# THE SOD GUY - SALES LOT

SITE DEVELOPMENT PLANS  
LOT 1, APPALOOSA HIGHWAY 24 SUBDIVISION

**THE SOD GUY - SALES LOT**  
**SITE PLAN**

# Site Plan\_v1-redline.pdf Markup Summary

THE SOD GUY - SALES LOT
SITE PLAN

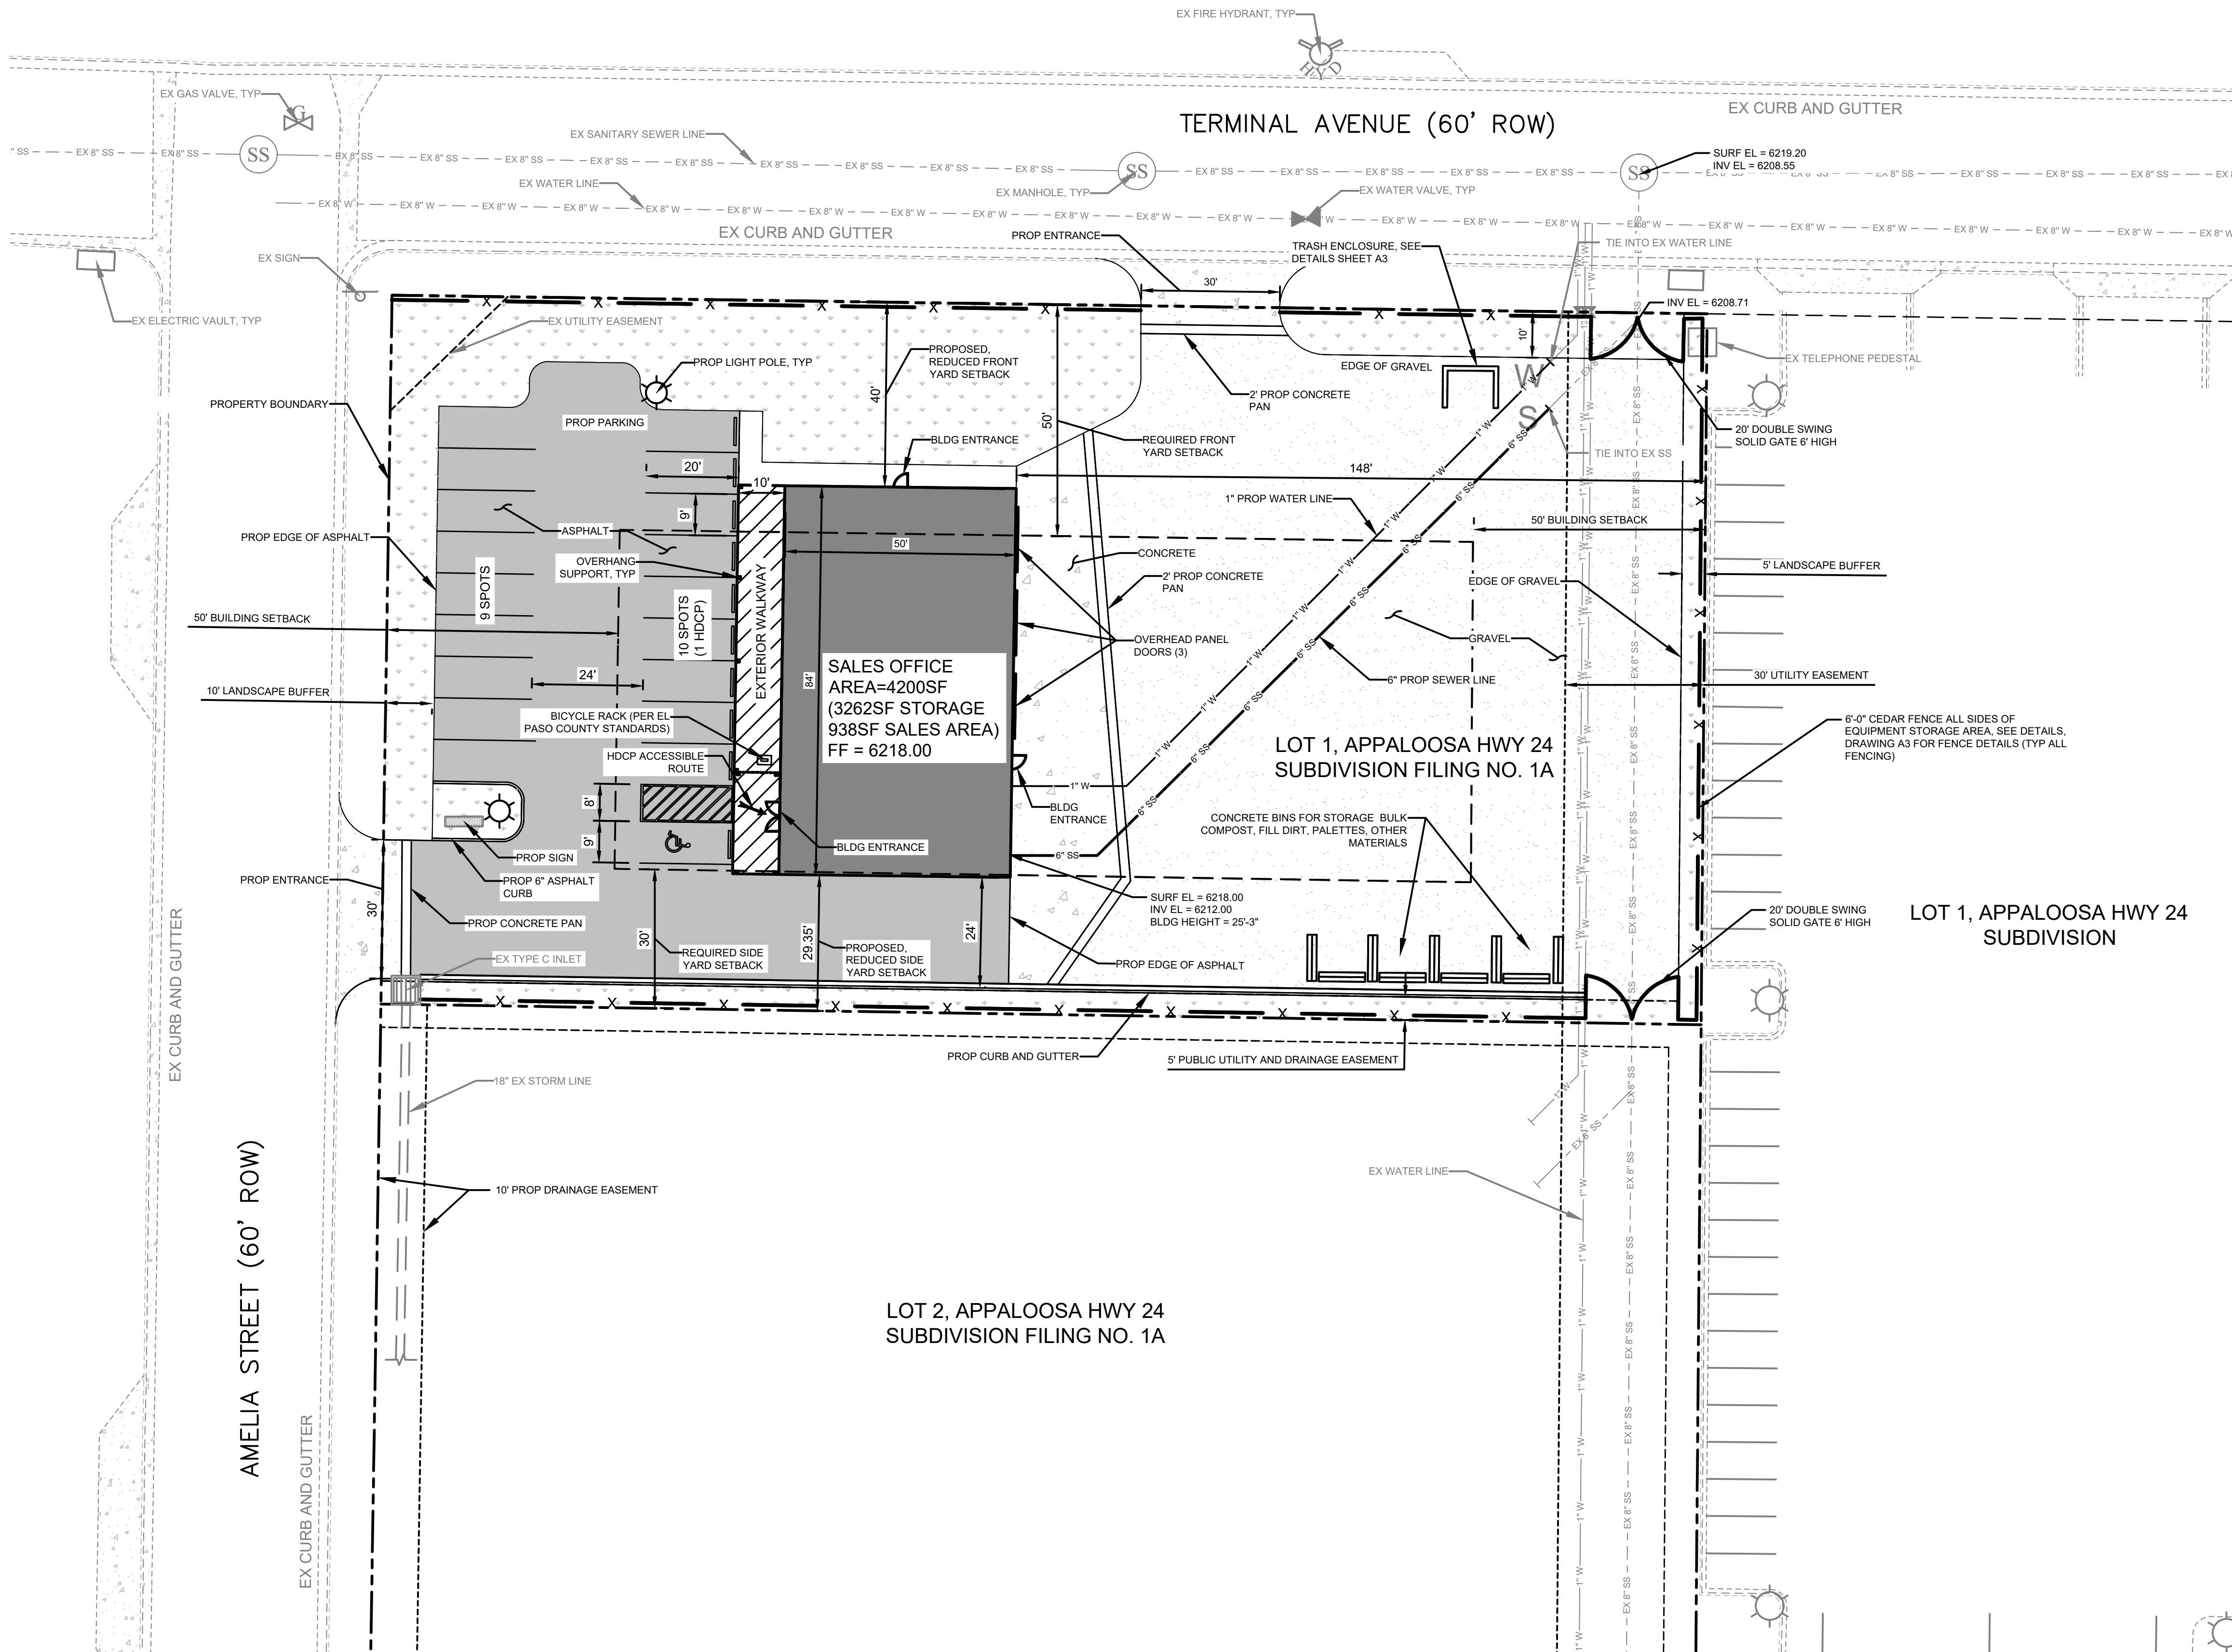
Identify where all storage will take place

Proposed access is equivalent to frontage, both fronts of the road are required to meet 50 foot front yard setback due to access.

Show trash enclosure.

Show this as office and warehouse and include appropriate square footages.
